**Re: BOWDENS SILVER PROJECT (AMENDMENT REPORT) - APPLICATION
NUMBER SSD-5765**

Attached is the Objection by Lue Action Group (**LAG**) to the Amendment as lodged by Bowden's Silver Project (Bowden's) to *State Significant Development [SSD]* – 5765 detailed within the Amendment Report for the Bowdens Silver Project (R.W. Corkery & Co. Pty. Limited, July 2021).

Project:	N4006_001 Bowdens Silver Visual Radial Analysis	Date:	18 August 2021
To:	Lue Action Group	From:	Rod Williams
ATT:	Phil English	CC:	Click or tap here to enter text.
Subject:	Visual Radial Analysis – Proposed Transmission Line

Figure 1 Potential Visual Catchments (Source Richard Lamb 2020)

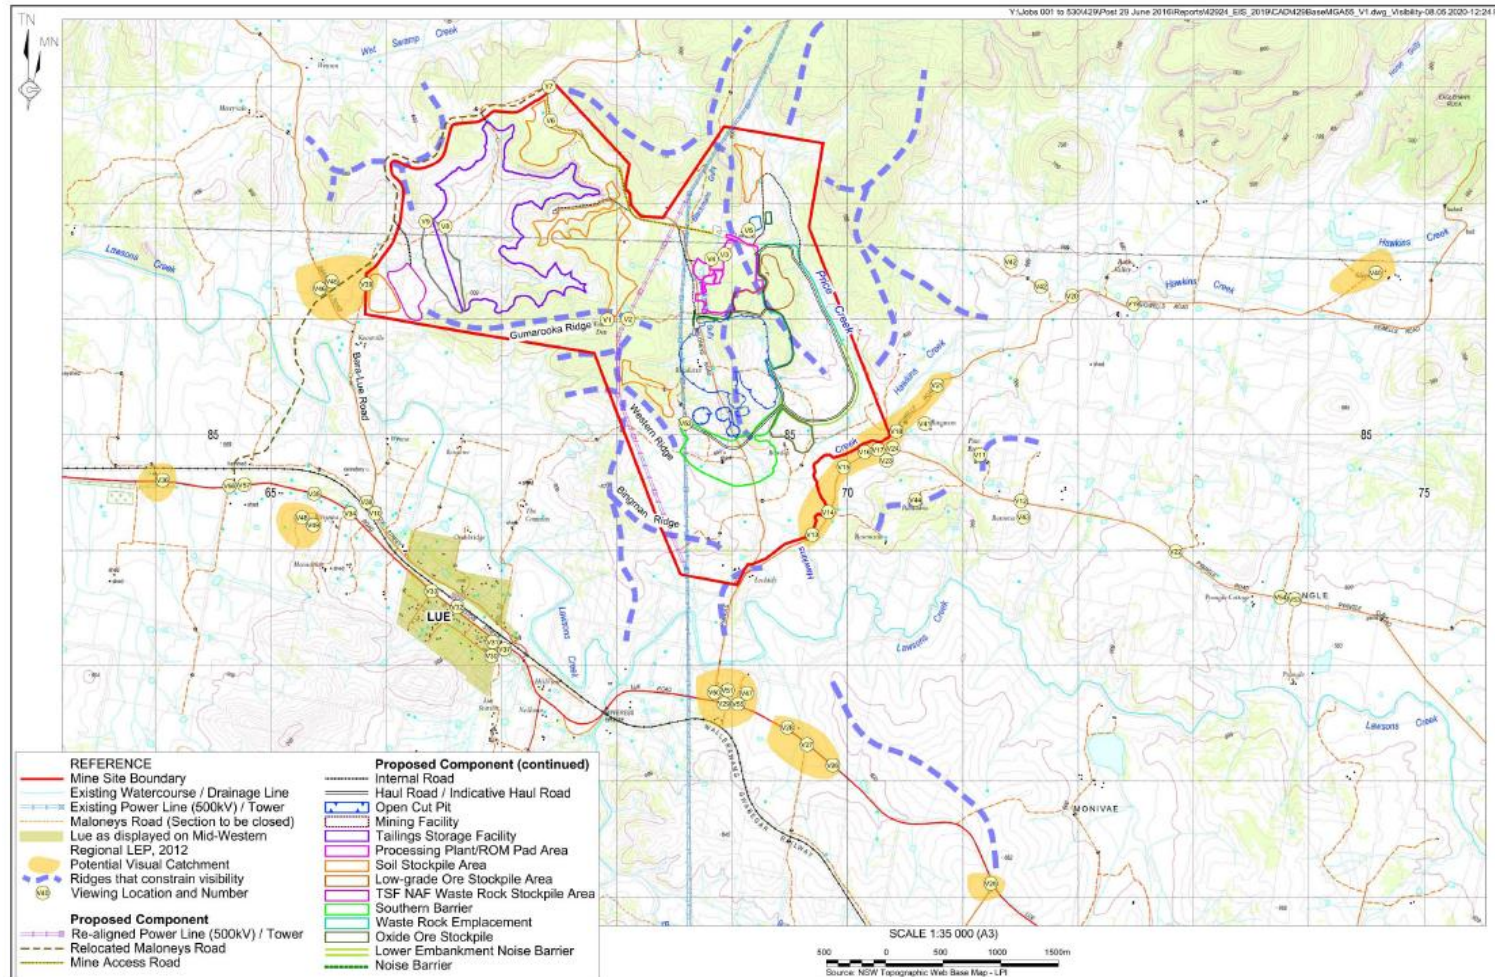
The village of Lue is located to the southern west of the proposed mine and the re-aligned power transmission line. Views from the Lue general area to the Northeast (i.e. towards the existing power transmission line) are completely screened by the existing natural topography (see Figure 1). Three cross sections from Lue to the existing transmission line alignment confirm that the views from Lue towards the Northeast are screened by the natural topography (see Figure 2, Figure 3 and Figure 4).

Figure 3 Tower 2 Cross Section

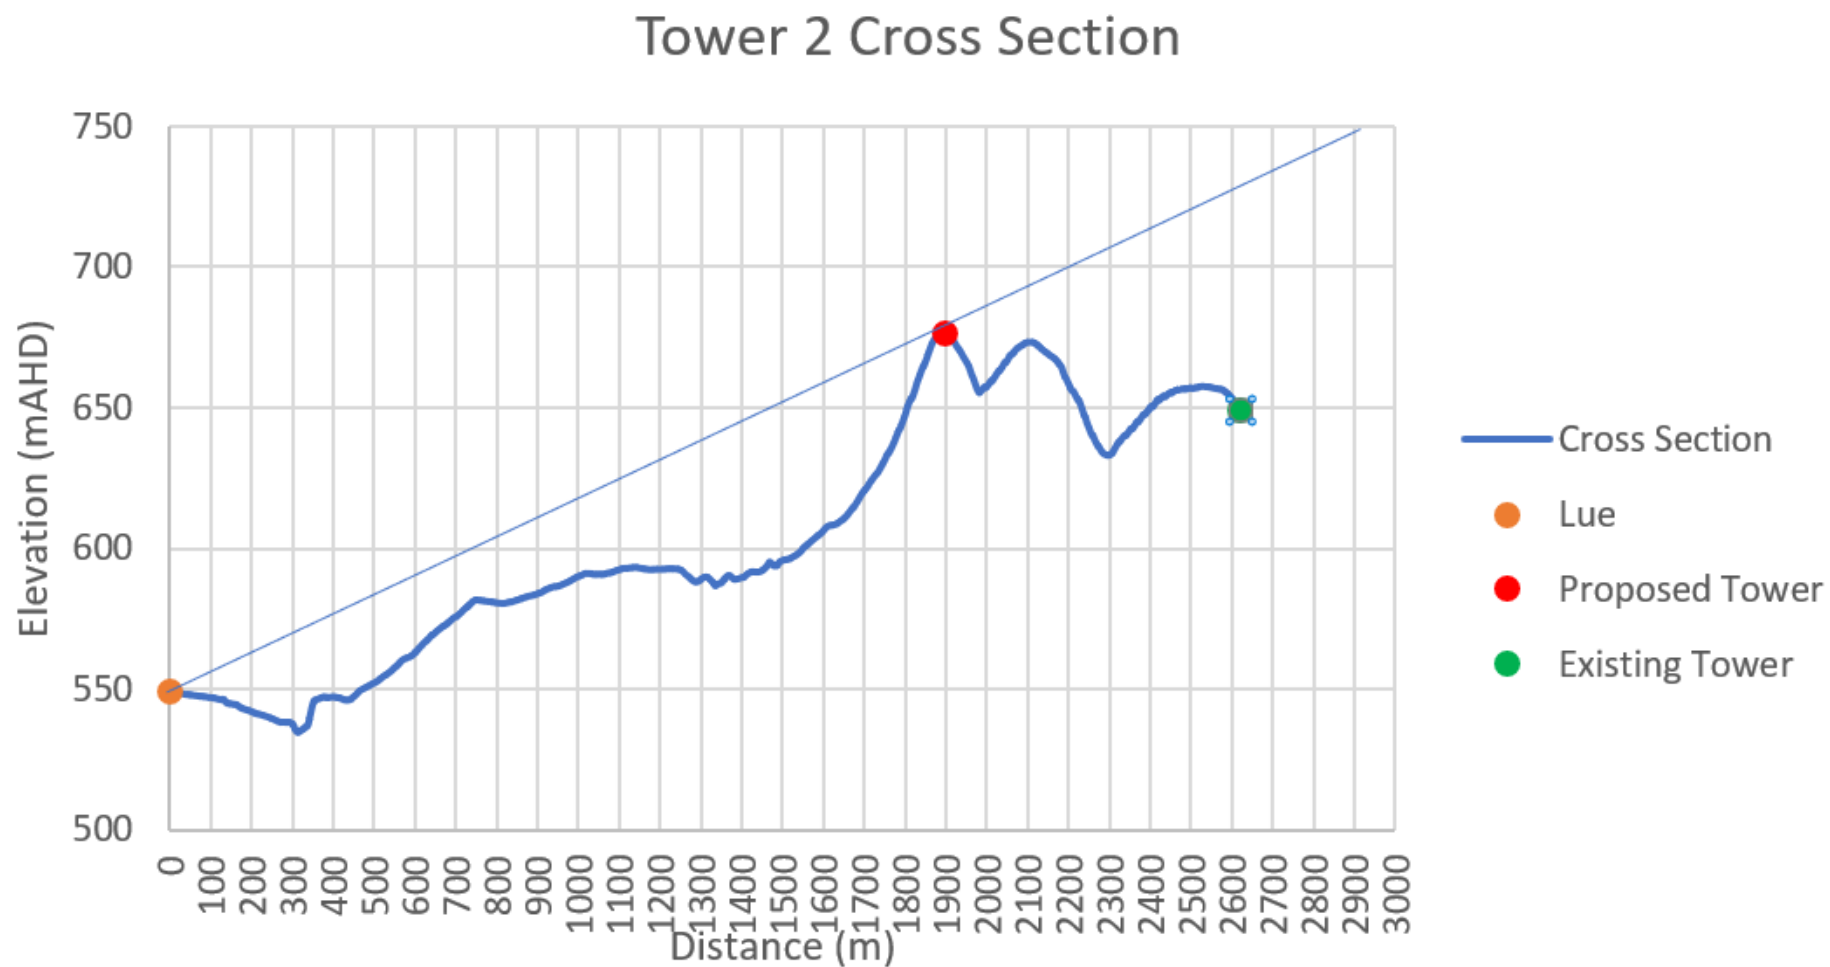
TOWER 2 CROSS SECTION

In what appears to be a significant discrepancy within their conclusions, Engeny determined that the Visual Impact from the realignment to be extremely significant to the Village of Lue and its surrounding areas.

“Based on this analysis it is expected that approximately 50% of the proposed re-aligned power transmission line will be clearly visible from the vast majority if not all receivers in the Lue Village and surrounding area. This represents a significant change the viewshed characteristics for the Lue Village and surrounding receivers, compared to the current situation.”

visible from the Lue general area. Towers 2 and 3 are however located on the top of the ridgeline (see Figure 3 and below Figure 4) and as such will be clearly visible from the Lue Village and surround area (see Figure 6 and Figure 7). The visibility of the proposed power transmission line alignment would be further increased by the clearance of vegetation within the powerline easement. The extent of vegetation clearance required has not been defined in any of the documents reviewed or the contribution to the visual impact assessed.

Figure 4 Tower 3 Cross Section

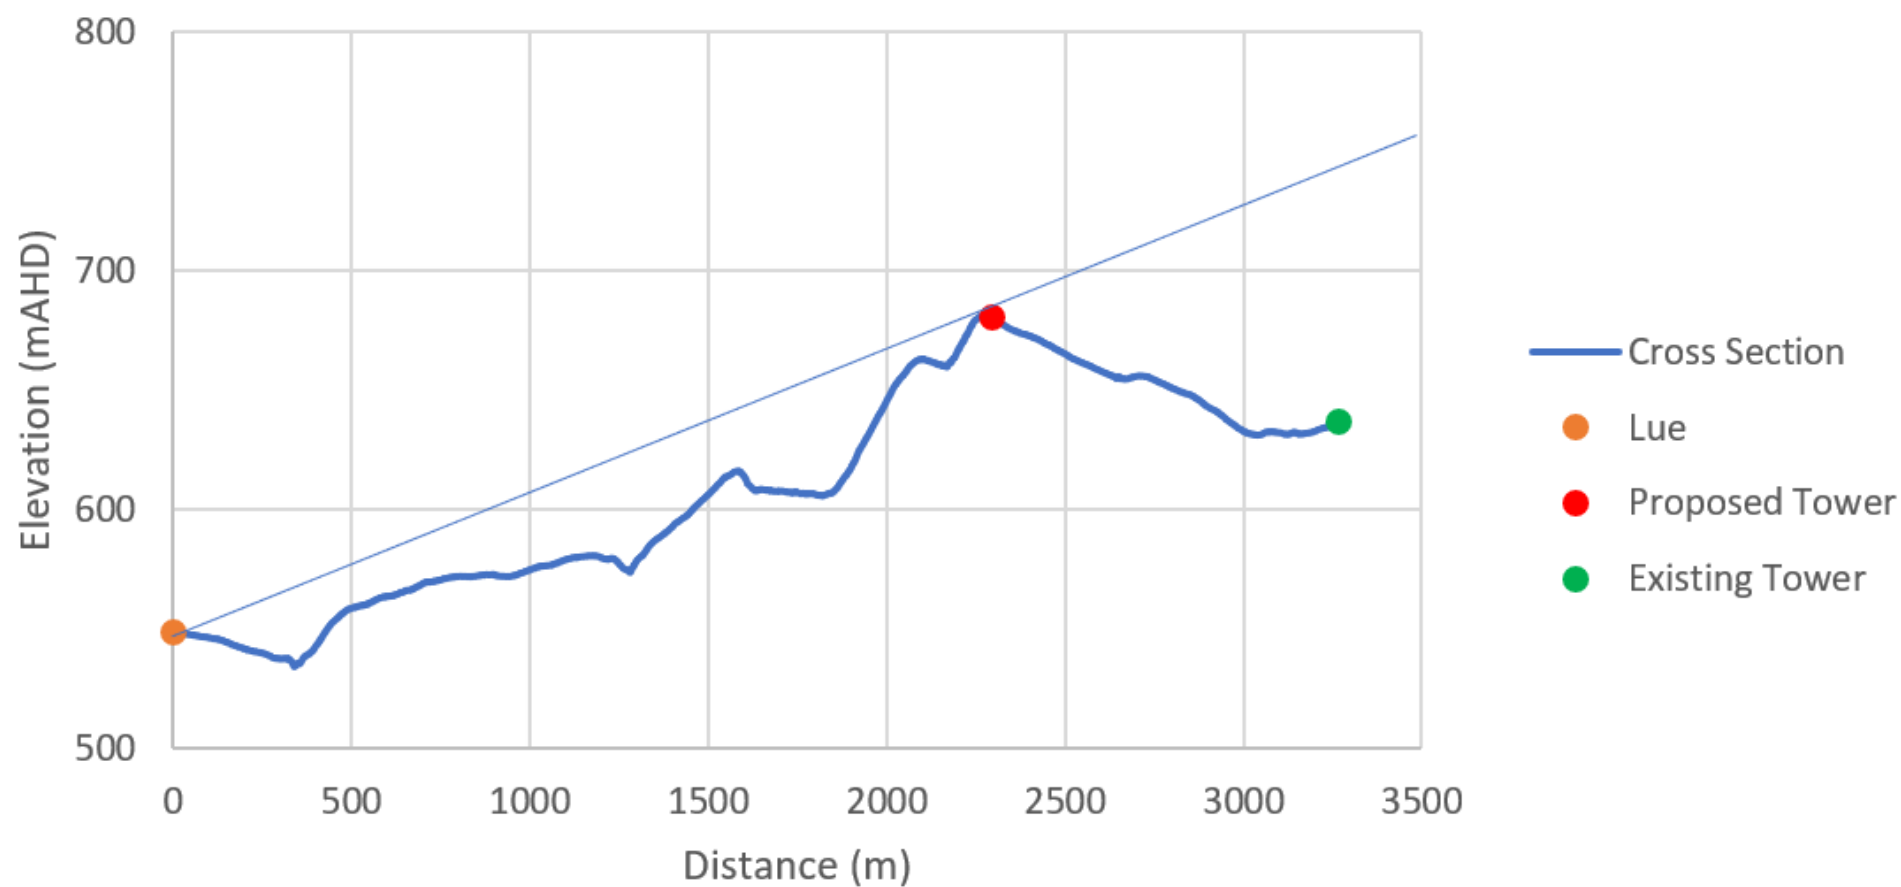
TOWER 3 CROSS SECTION

Figure 5 Tower 1 Radial Analysis

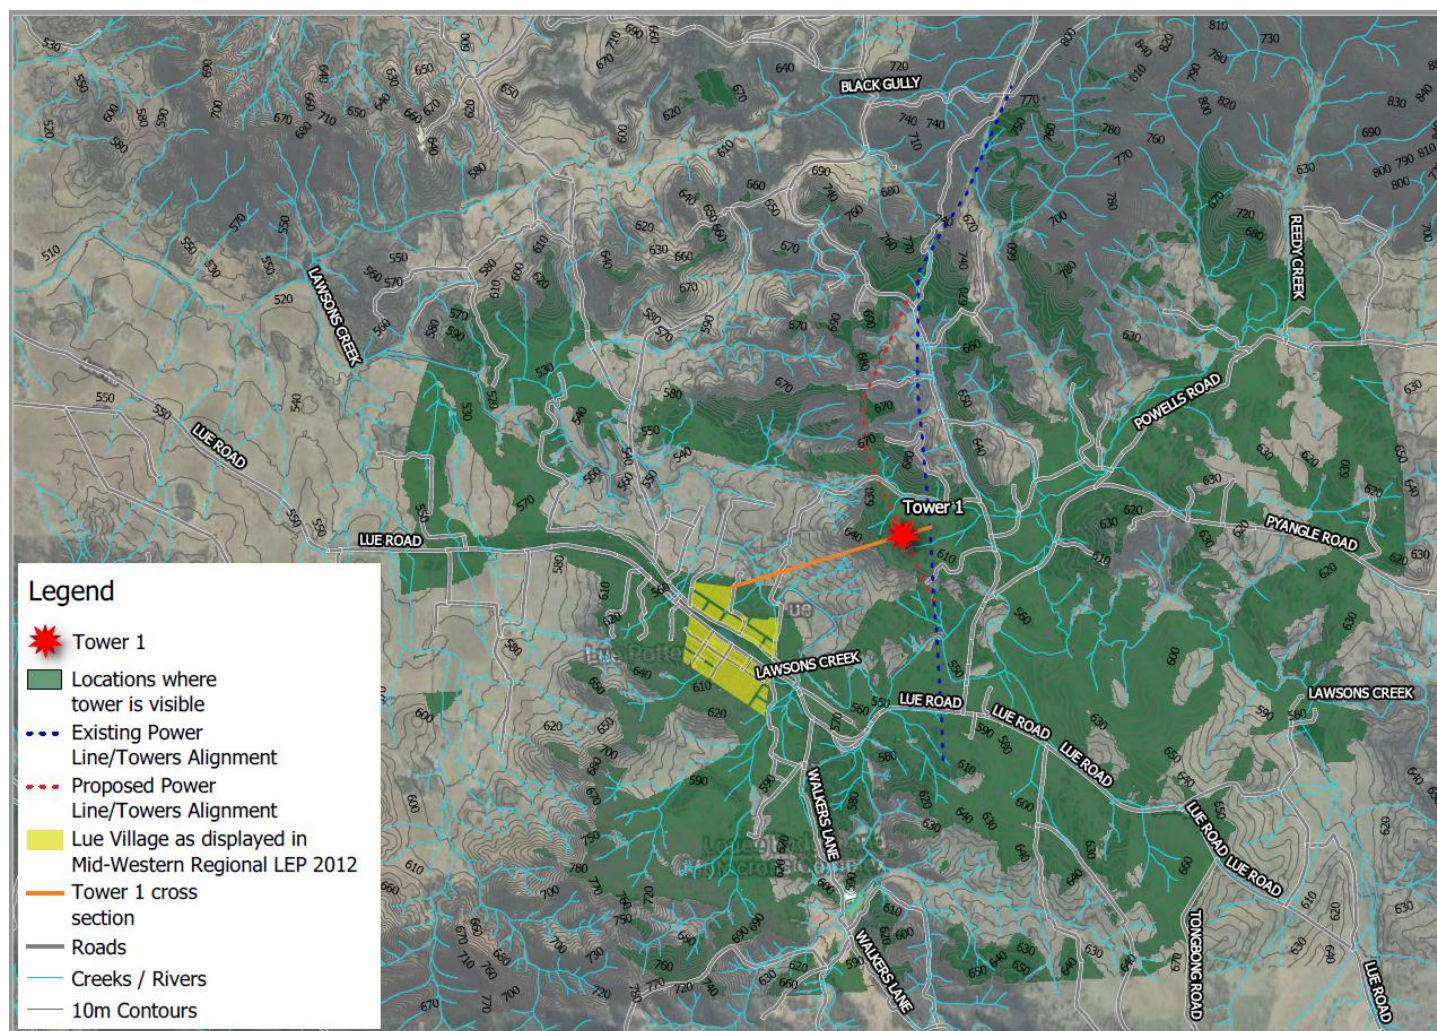
Radial analysis of three tower locations (assuming a tower height of 60m and a viewshed of 5 kilometres from the tower) along the re-aligned power transmission line alignment has been undertaken to assess the extent to which the proposed towers will be visible from the general area of Lue (see Figure 5, Figure 6 and Figure 7). The Tower 1 radial analysis (see Figure 5) and cross section (see Figure 2) indicates that the top portion of Tower 1 will be visible from the Lue general area. However, this assumes that there is no screening provided by the existing vegetation, which is not the case. As such Tower 1 is unlikely to be

Figure 6 Tower 2 Radial Analysis

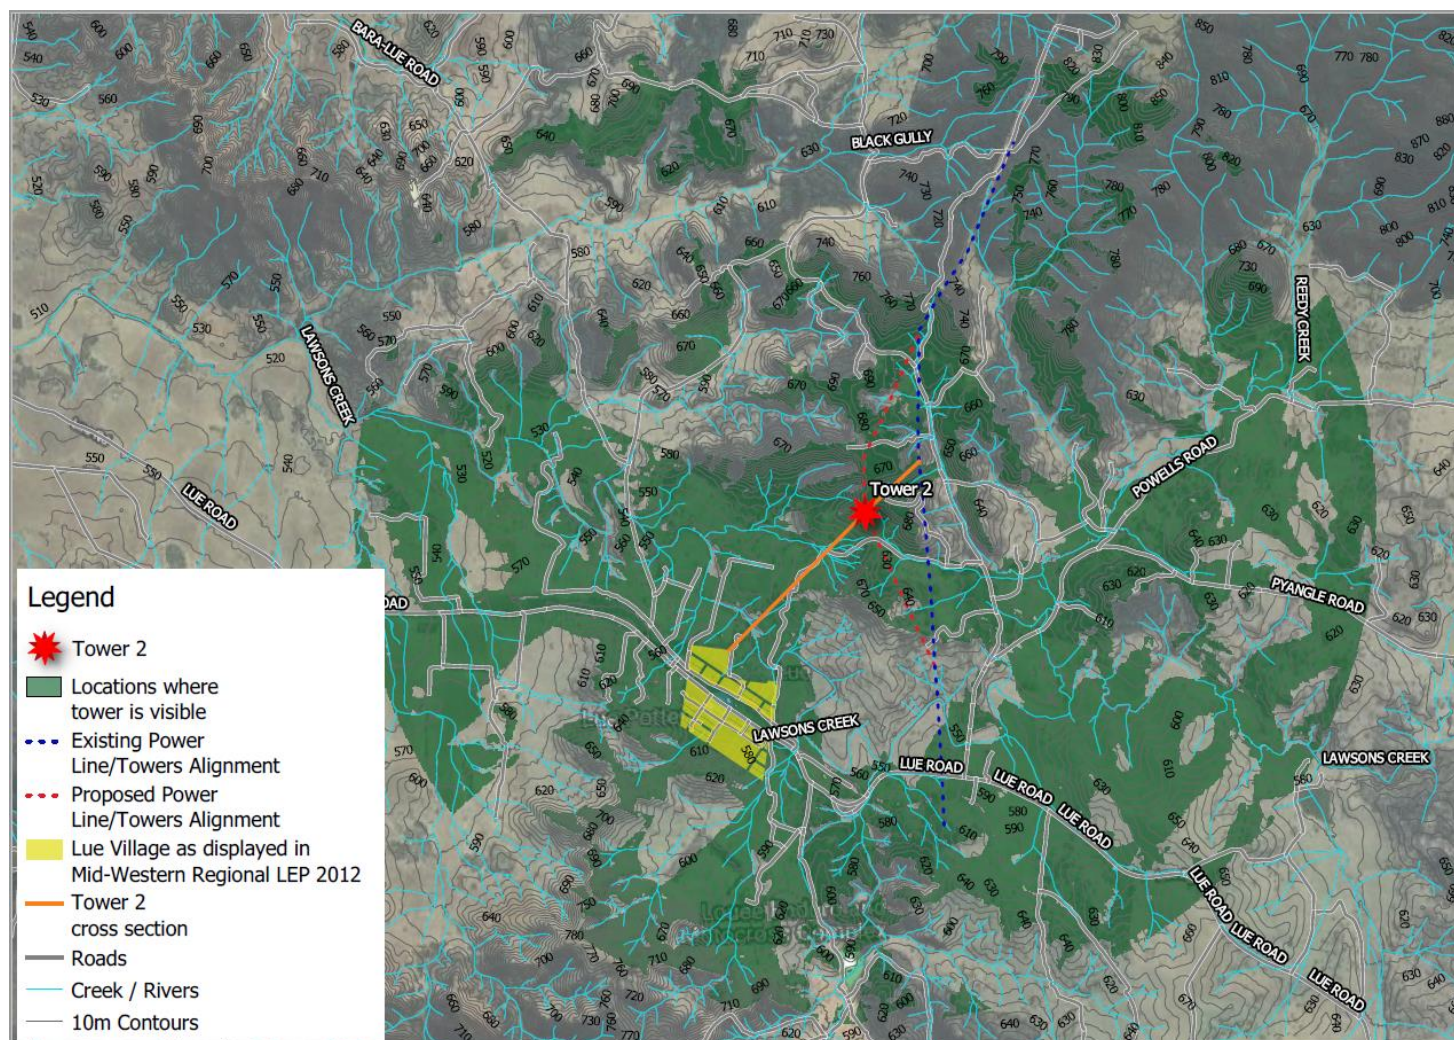
Based on this analysis it is expected that approximately 50% of the proposed re-aligned power transmission line will be clearly visible from the vast majority if not all receivers in the Lue Village and surrounding area. This represents a significant change the viewshed characteristics for the Lue Village and surrounding receivers, compared to the current situation.
